APPLEGREEN PLC

DEADLINE 6 SUBMISSION

**M42 Junction 6
Development Consent Order Application**

COMMENTS ON RESPONSES RECEIVED AT DEADLINE 5

Figure 1: Junction 5a Free Flow Alternative Layout

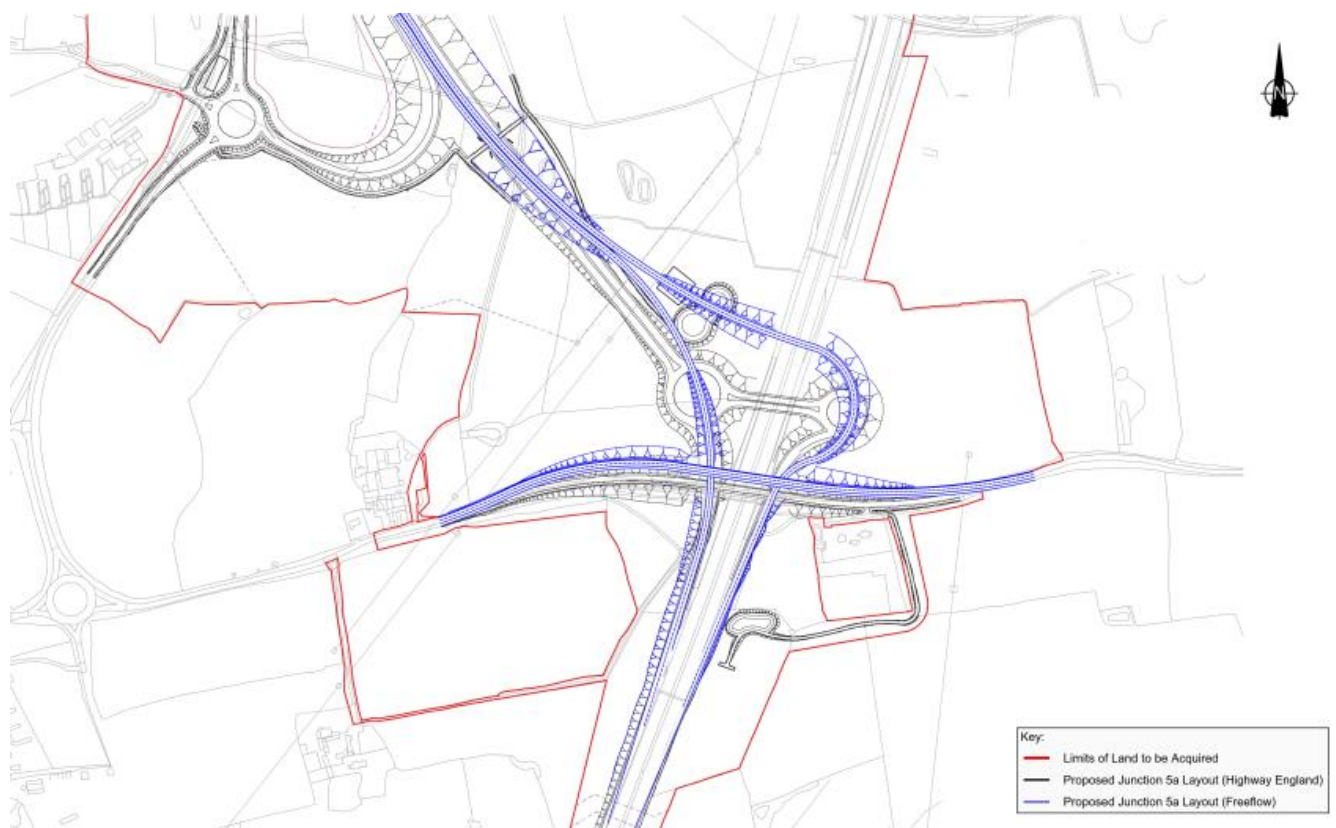
The free-flow restricted layout presented by Applegreen in their response to ExAQ 2.1.4 [REP4-025] also suffers from this lack of flexibility. This is recognised by TD 22/06 section 5.19 which identifies this as a limitation of a free-flow layout, referred to in TD 22/06 as a “trumpet” interchange:

“The three way ‘trumpet’ interchange (Figure 5/4.2d) should be designed to enable future conversion to a four way without alteration if this is considered a possibility. It has a 2 way slip road which requires careful design for safety. Figure 5/4.2e shows a three way interchange with restricted movement. This enables high vehicle speeds to be maintained with low land take, but it requires a costly skew structure and prohibits any future conversion”.

flow proposal and the impacts of the dumb-bell arrangement on efficiency and safety. In relation to the last two issues, the dumb-bell arrangement will require vehicles to slow down and introduce conflicts where vehicles are required to give-way, whereas with a free-flow arrangement, vehicles will be able to maintain a constant speed and, because all vehicles will be travelling in the same direction, there will be a much lower potential for vehicular conflict.

The Applicant’s comment regarding the preclusion of future development aspirations to connect with the SRN is not accepted as there are no planned infrastructure or development proposals to the west of the M42 that would require a motorway connection at Junction 5A. In the unlikely event of a proposal coming forward in the future, the promoter/developer of the scheme would need to make the necessary changes to the layout of Junction 5A if a connection to the motorway at this junction was considered an integral part of the scheme.

The Applicant comments that the free-flow arrangement presented previously by Applegreen suffers from a lack of flexibility and that this is recognised by TD 22/06 section 5.19 which identifies this is a limitation of a free-flow layout, referred to in TD 22/06 as a “trumpet” interchange:

“The three way “trumpet” interchange (Figure 5/4.2d) should be designed to enable future conversion to a four way without alteration if this is considered a possibility. It has a 2 way slip road which requires careful design for safety. Figure 5/4.2e shows a three way interchange with restricted movement. This enables high vehicle speeds to be maintained with low land take, but it requires a costly skew structure and prohibits any future conversion”.

TD 22/06 was superseded by CD 122 in August 2019. The Applicant acknowledges this and notes that the ‘updates to this standard do not change or affect the points made in this response’.

It should however be noted that the shaded sections in the extract from TD 22/06 shown above, have been removed from CD 122. This is significant because it removes any reference to the future conversion of the junction implying that this
